Our Ref: LU/321/18/HH
Your Ref:

Town & Country Planning Act 1990 (as amended)
Town & country Planning (Development Management Procedure) (England) Order 2015
Application for Planning Permission for Works or Extension to a Dwelling

Development Loft conversion with hipped roof changed to gable end. Flat roofed dormers to front and rear
Location 13 Grand Avenue Littlehampton

West Elevation

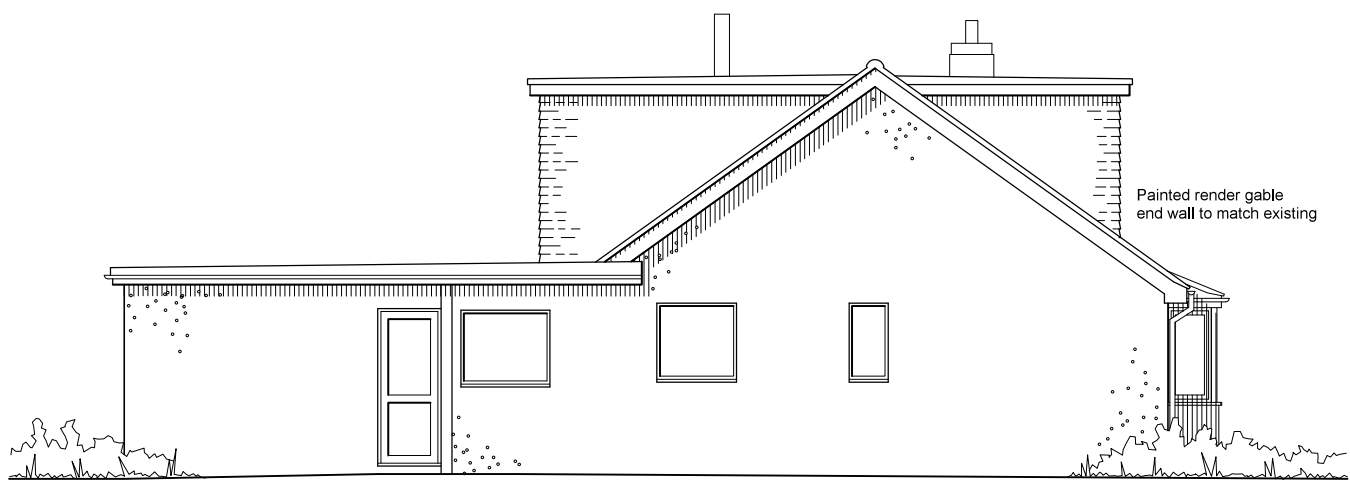
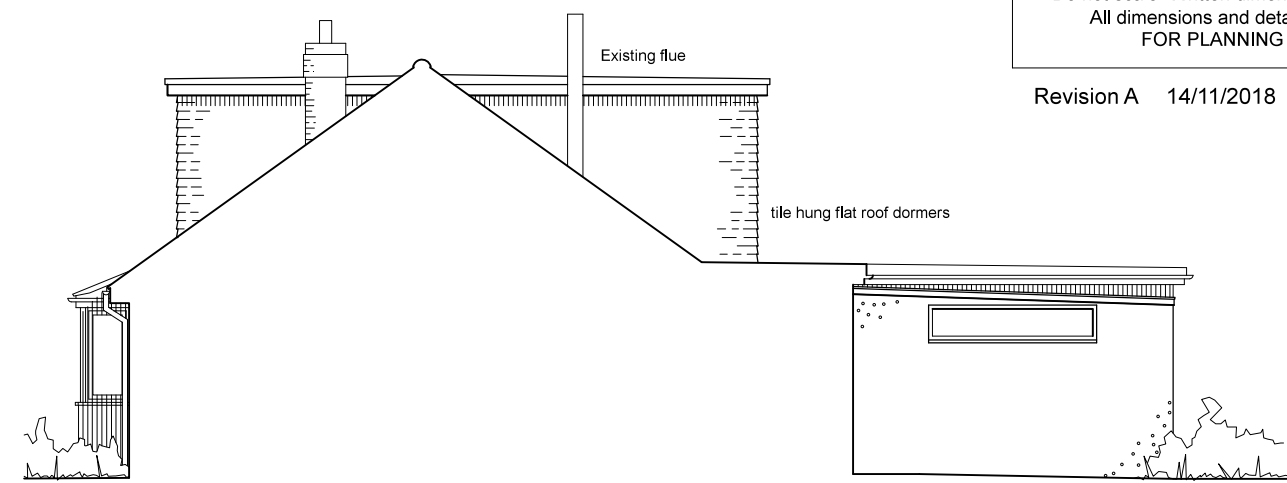
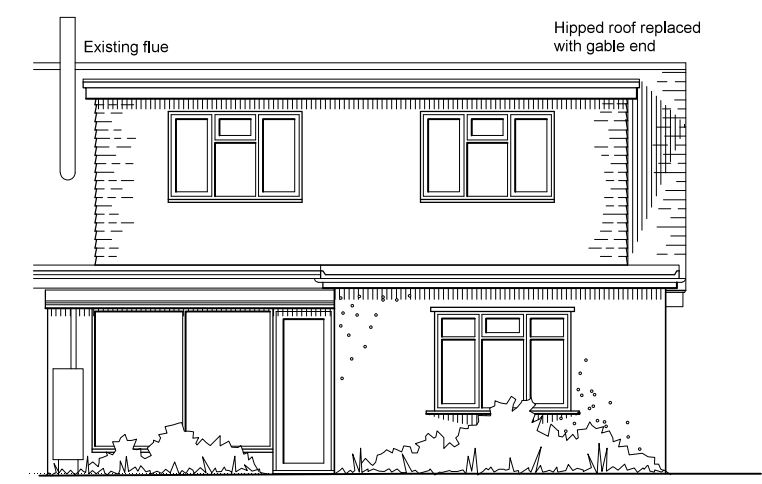
Other Side Elevation Required: Please provide the other side elevation as the proposal extends past the existing building line of the neighbouring property. Please submit this at a stated standard metric scale such as 1:50 or 1:100, with a scale bar or dimensions annotated to allow the confirmation of the scale.
